CITY OF ALBUQUERQUE

**Re: Montecito West Unit 1, Grading and Drainage Partial Certification
Engineer's Stamp Date 3-16-14 (D09/D004)
Certification dated 7-11-14**

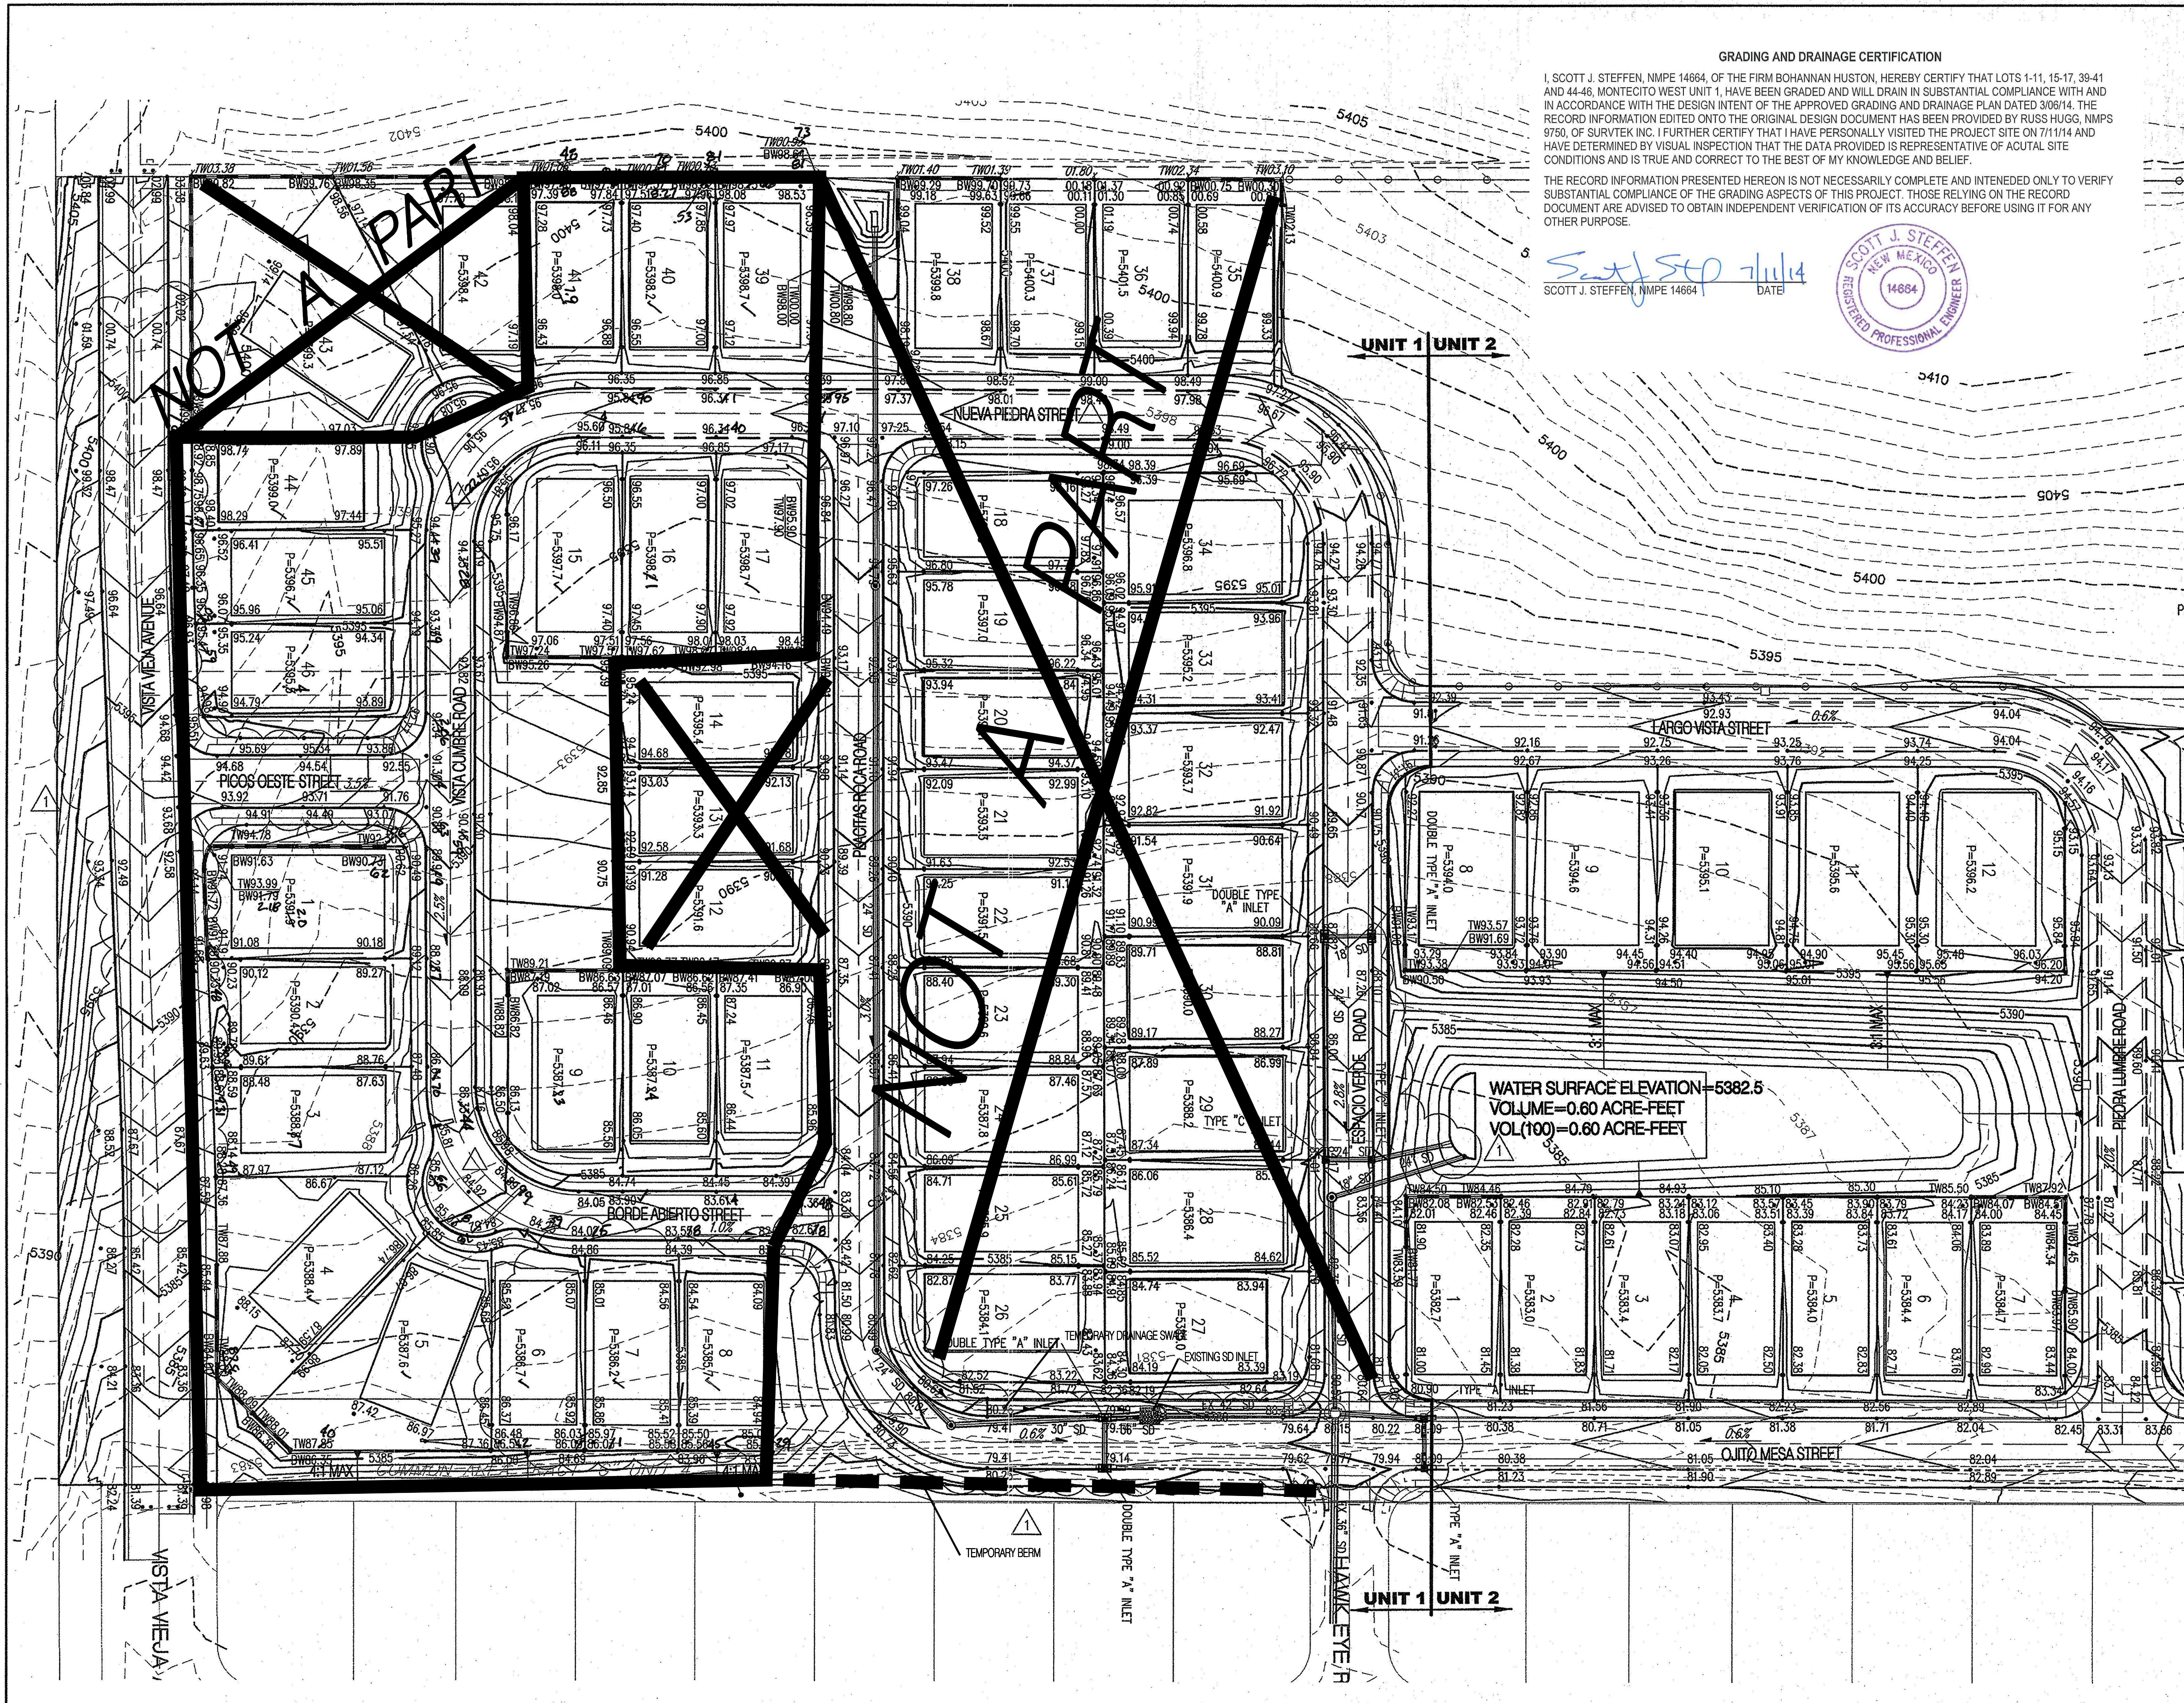
- The site does not drain in substantial compliance with the drainage report and the interim swale indicated in your letter was not present. It appears that drainage will leave the end of Borde Abierto St. enter the excavation for the storm drain then flow into the Vista Vieja Subd. The inlet mentioned in your letter is 4 feet higher than the adjacent flow line and stormwater will not enter it.
- The berm pond that was engineered to protect these homes was not constructed. The berm pond is to be certified and included in your certification.
- We are in the middle of the monsoon season and the site is not ready for additional impervious area.

In addition, numerous dirt and rock piles have been dumped, linear holes have been dug and the area immediately west of the subdivision has been disturbed on adjoining properties. Please refer me to the appropriate person at Pulte Homes so I can further discuss this matter.
